ACCESS REPORT

RACECOURSE PL, EVANS AVE & BARBER AVE EASTLAKES TOWN CENTRE

MIXED RESIDENTIAL / RETAIL DEVELOPMENT

Prepared By Mark Relf
17th July 2012

DRAWING TITLE:  
**BUILDING 1 & 1B LAYOUTS**

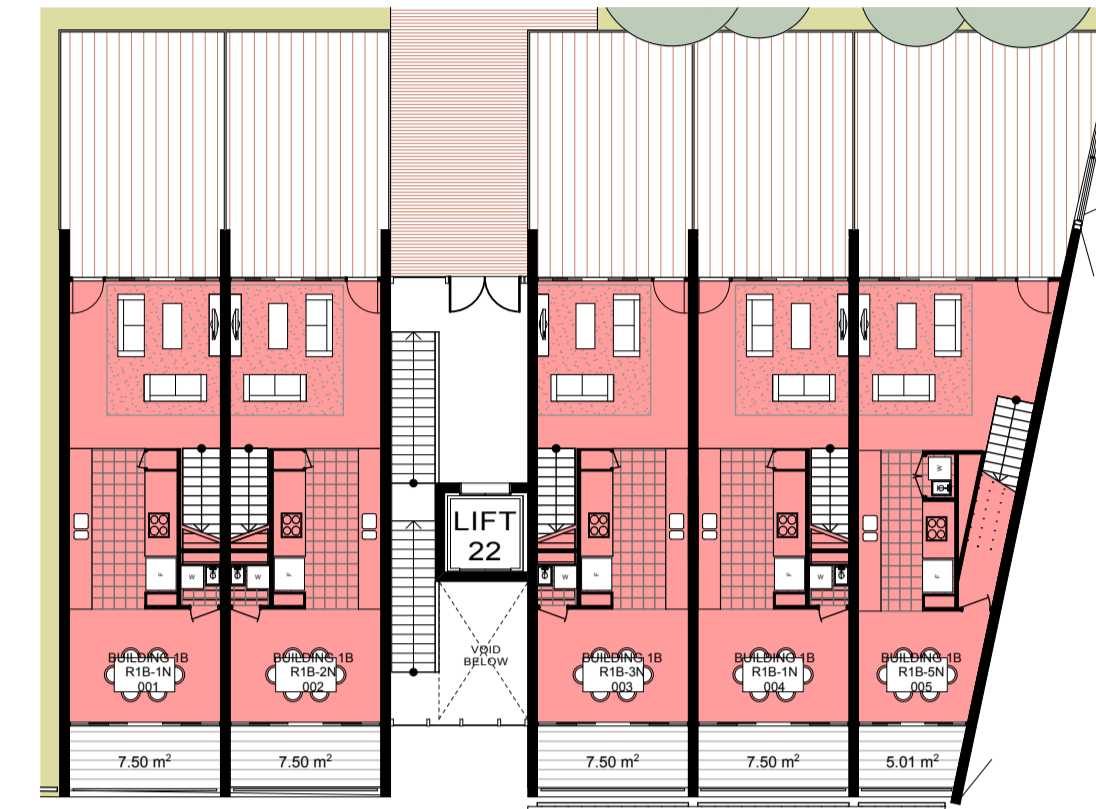
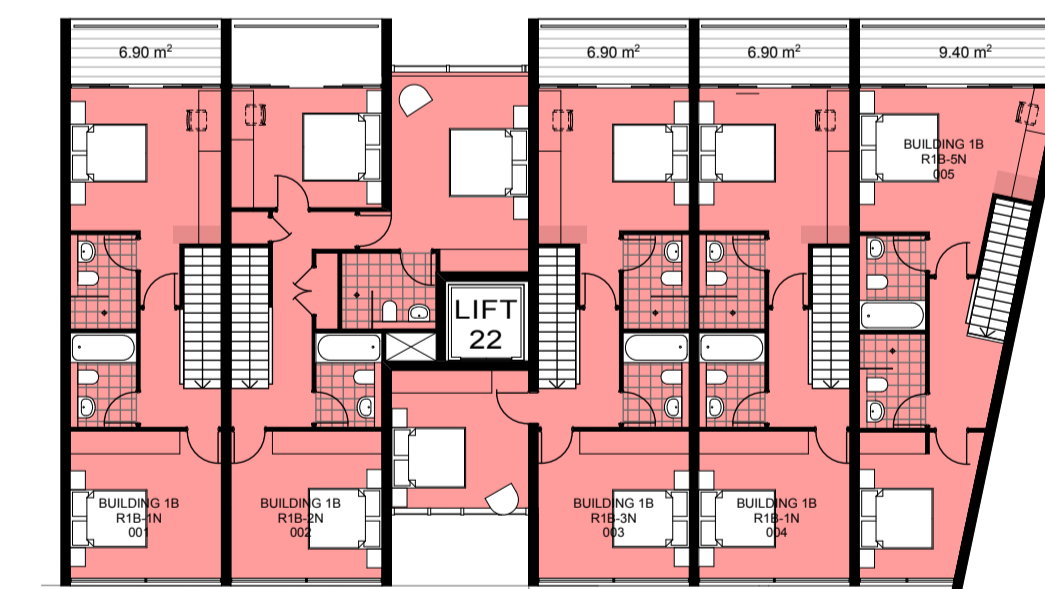
AS4299 Cls 4.3.7	<p>Interior: general – The pre adaptation plans provide open plan living areas with direct access to the main bedroom doorways in accordance with AS1428.1/4299, except for;</p> <ul style="list-style-type: none"> Building 1 Adaptable apartments require the 2600mm length bathroom to be increased to 2750mm minimum and the laundry adjusted to enable the bathroom door to achieve the required circulation space. Building 5 Adaptable apartments require the 1240mm width 	YES At CC Stage At CC

AS4299 Clause 4.6	Main bedroom – The plans show the main bedroom for the; <ul style="list-style-type: none"> Building 1 X 1 bedroom layouts will be at least 3200mm x 4500mm providing 1540mm X 2070mm circulation space at the side of the bed and a 1000mm-1500mm on the other sides of the queen sized bed with appropriate doorway circulation spaces to enter/exit the room and access the robe area to satisfy AS4299/1428. Building 3 X 2 bedroom layouts will be at least 4000mm x 4100mm providing 1540mm X 2070mm circulation space at the side of the bed and a 1000mm-1500mm on the other sides of the queen sized bed with appropriate doorway circulation spaces to enter/exit the room and access the robe area to satisfy AS4299/1428. Building 7 X 1 bedroom layout will be at least 3600mm X 3400mm providing 1540mm X 2070mm circulation space at the foot of the bed and a 900mm on the window side and 1000mm on the doorway side with appropriate doorway circulation spaces to enter/exit the room and access the robe area to satisfy AS4299/1428, subject to the modification of the linen cupboard. 	YES

DRAWING TITLE:
BUILDING 7 LAYOUTS

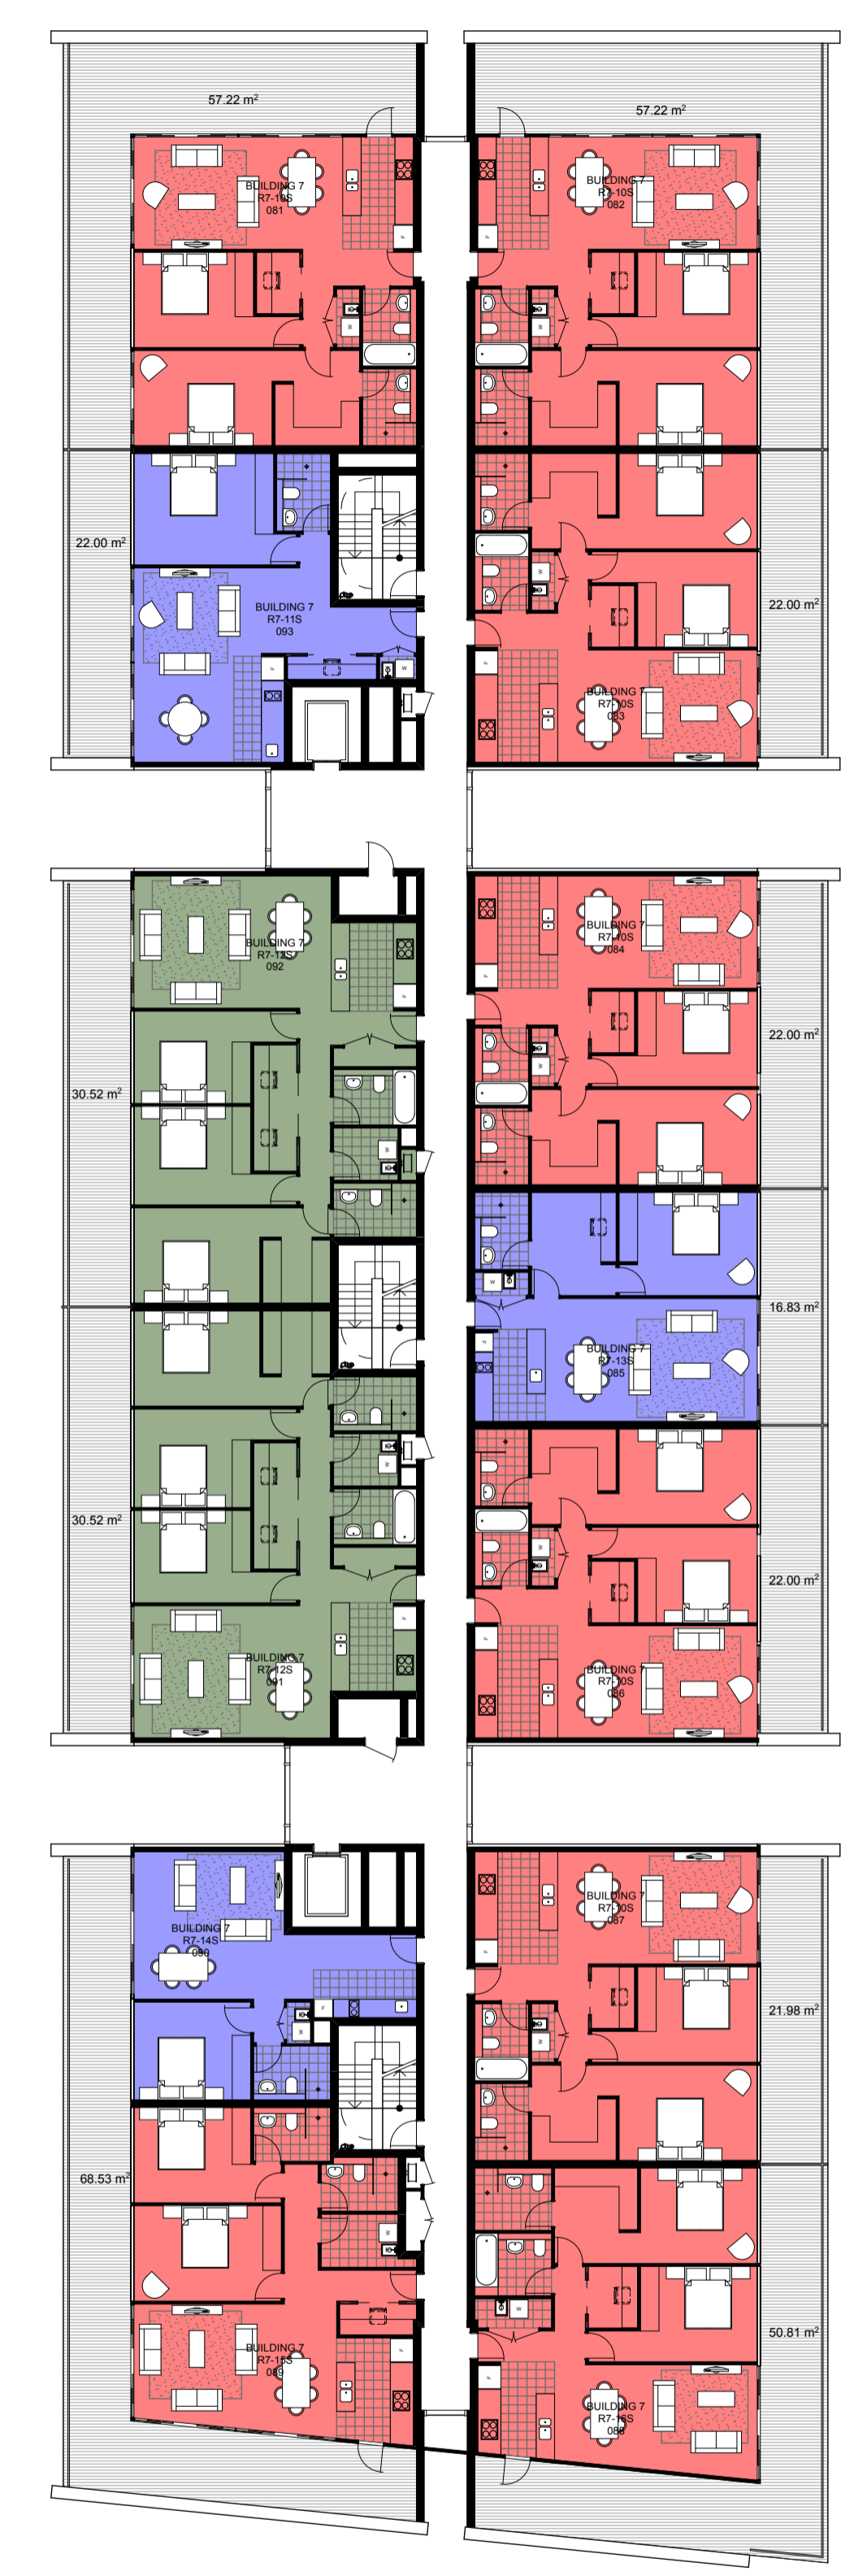
Clause	Adaptability Assessment	Compliance
	corridor to the bedroom and adjacent bathroom to be modified to achieve 1600 X 1600 circulation space at the doorway.	Stage
	<ul style="list-style-type: none"> Building 7 Adaptable apartments require the entry door to be rehinged from the opposite jamb to enable at least 530mm latchside clearance at the doorway. 	At CC Stage
	Doors and Door Hardware While the plans do not indicate 920mm external door widths, 870mm internal door widths and lever handles these details should be provided at construction drawing stage to confirm compliance.	YES
AS4299 Clause 4.7	Living and Dining rooms – The plans show combined living and dining area on a single level with sufficient area to provide a 2250mm diameter turning area to comply with this clause.	YES
AS4299 Clause 4.5	Kitchen – The kitchen post adaptation plans provide the required 1550mm minimum circulation space adjacent to the benches and appliances to comply with AS4299 requirements. With regard to the “adaptability” of the kitchen the pre-adaptation plan provides an appropriate layout of sink, fridge, wall oven, cooktop while the post adaptation plan proposes a height adjustable workbench that is readily adaptable and satisfies the “ease of adaptation” guidelines outlined in section 2 – Performance Objectives of AS4299. Therefore, subject to confirmation of the installation of kitchen cupboards, appliances and the like at the construction documentation stage it is apparent that the kitchen will comply with AS4299.	YES

BUILDING 4 & 4A LAYOUTS

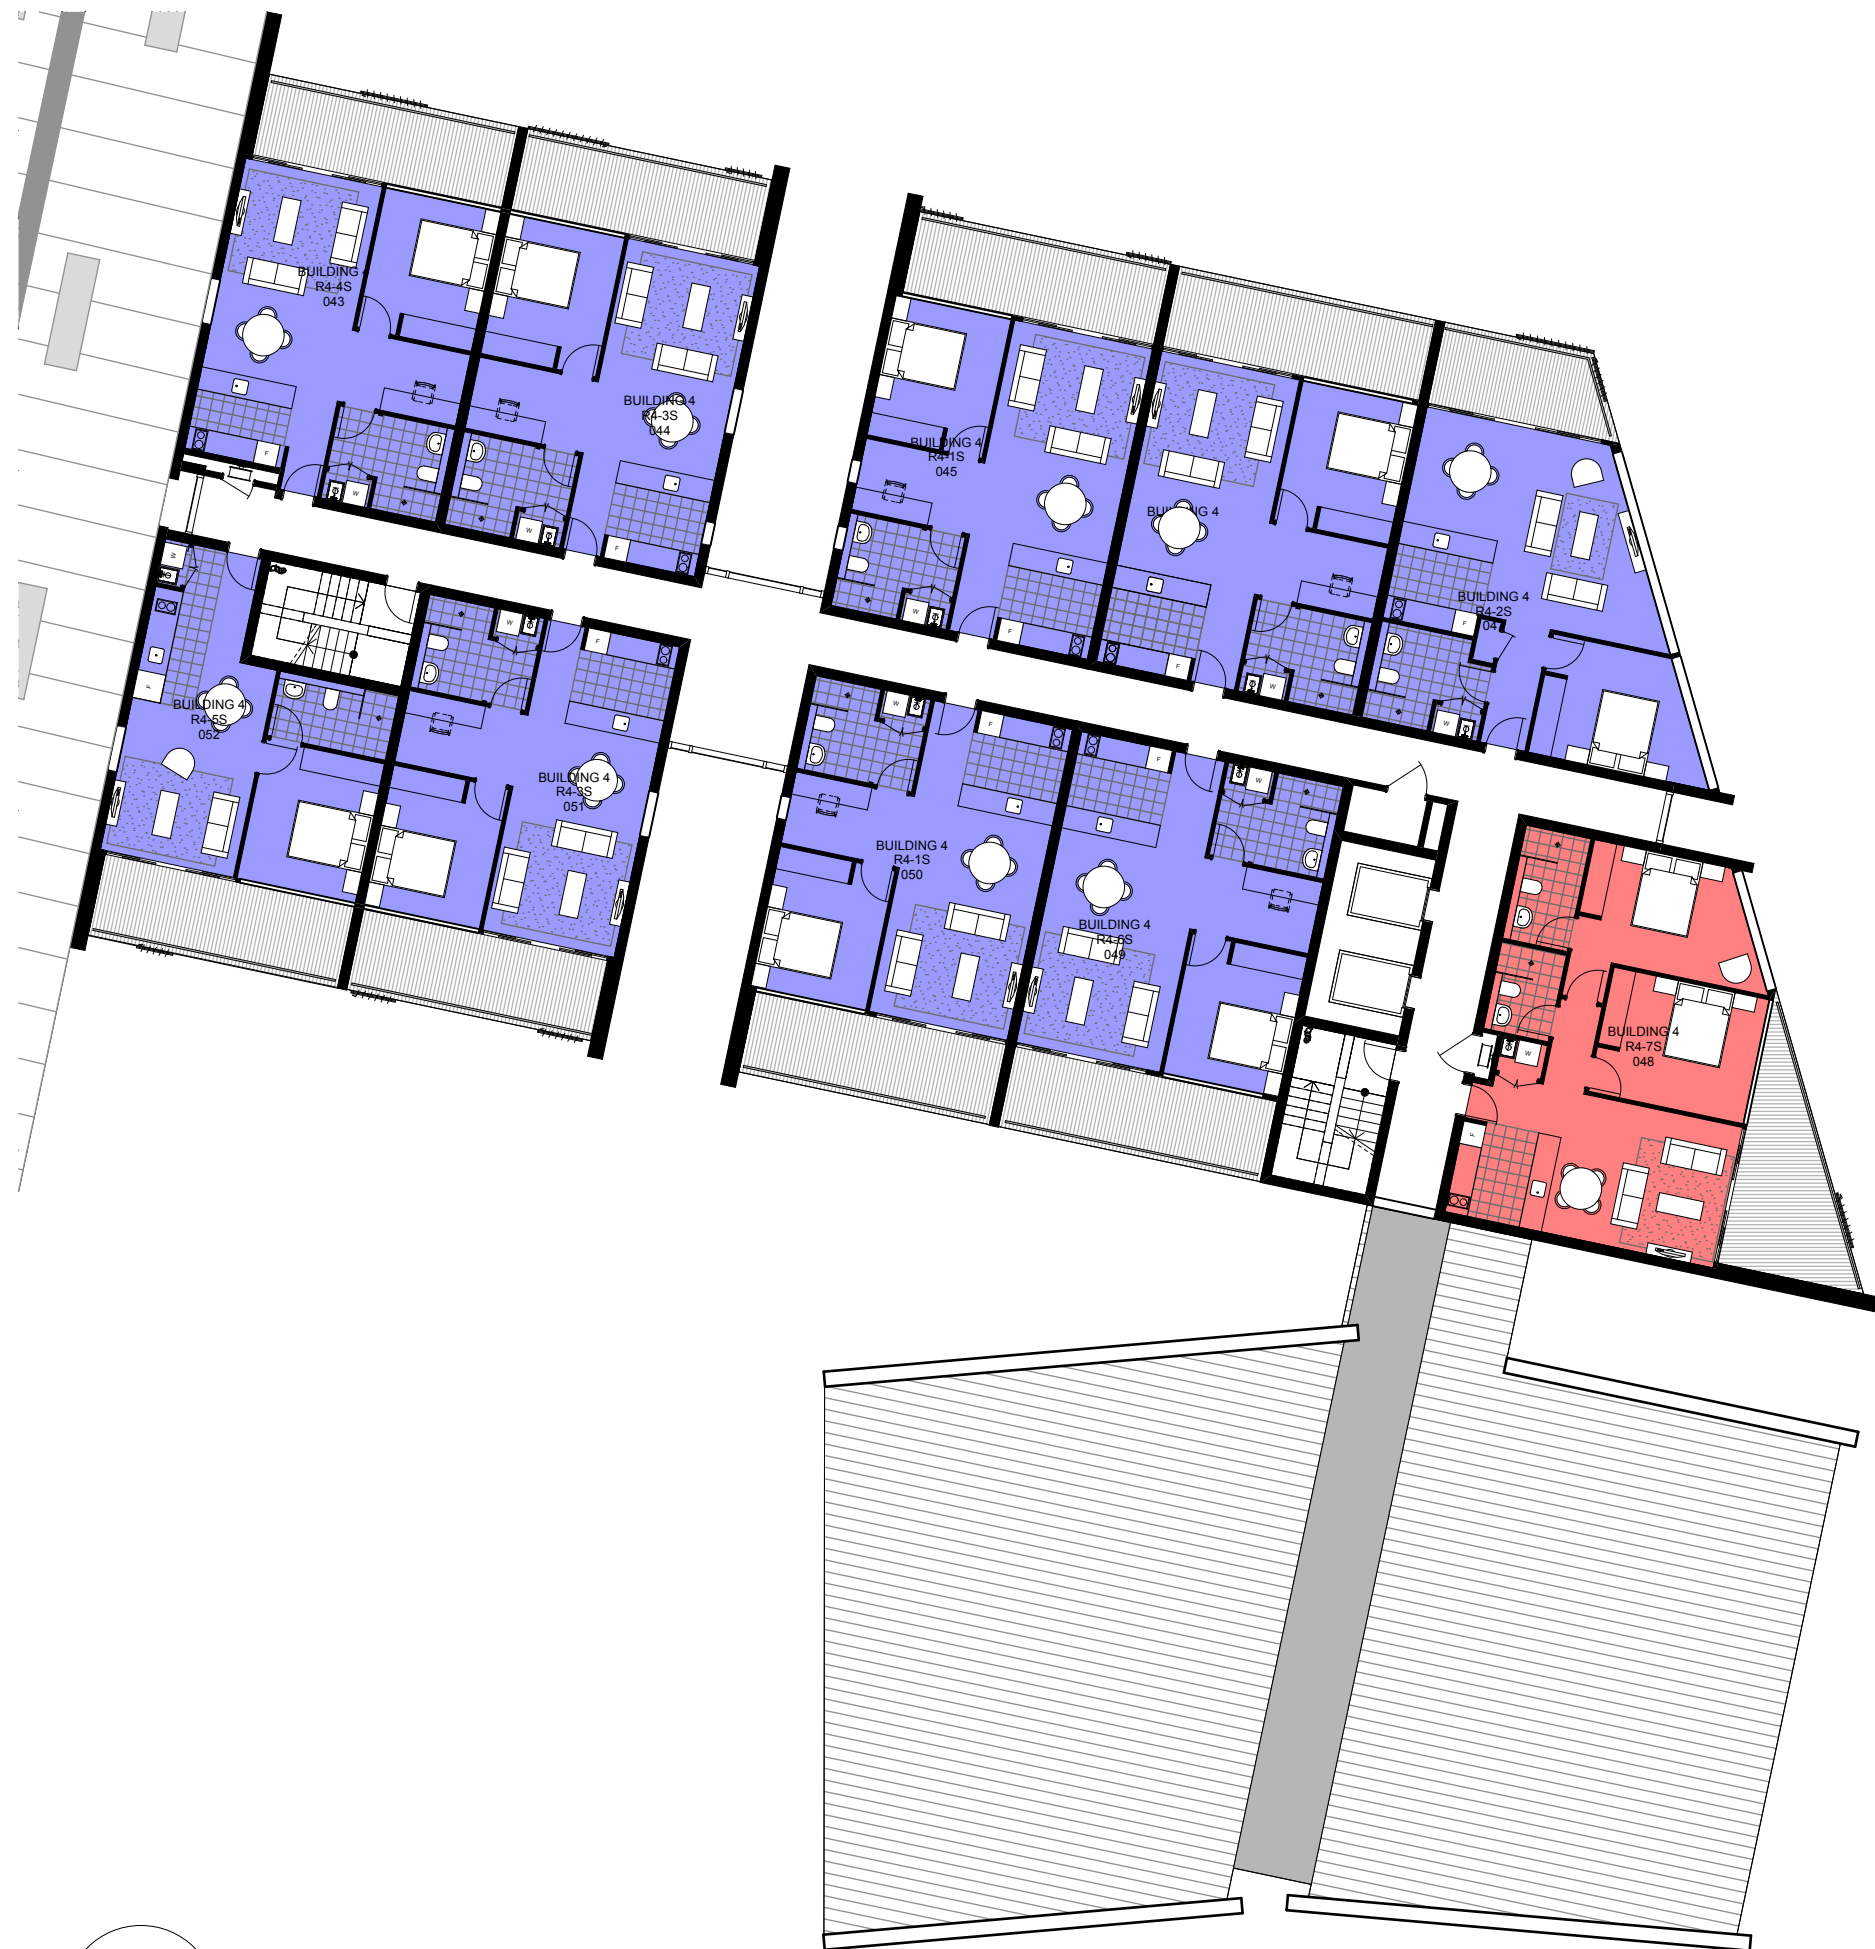
BCA / DDA Compliance		Complies
	Type 1 layout (4) shall comply with ASI428.1 subject to the entry door and foyer area being modified to ensure 530mm minimum clearance between the door and kitchenette on the door latchside.	YES at CC stage
	Type 2 layout (1) shall comply with ASI428.1 subject to the entry door and foyer area being modified to ensure 530mm minimum clearance between the door and kitchenette on the door latchside.	YES at CC stage
<p>31. Level 1 Podium Area North – The plans show a communal resident area on the Level 1 podium that will be accessible from all level accessways from all of the building lift lobbies to ensure equitable access and satisfy Table D3.1 of the BCA.</p> <p>32. Details of the pool, deck area, change rooms and pool house shall be confirmed at a future design stage in accordance with ASI428.1 to satisfy BCA/DDA Access Code Parts D3.3, F2.4 and D3.10 for swimming pools.</p>		YES
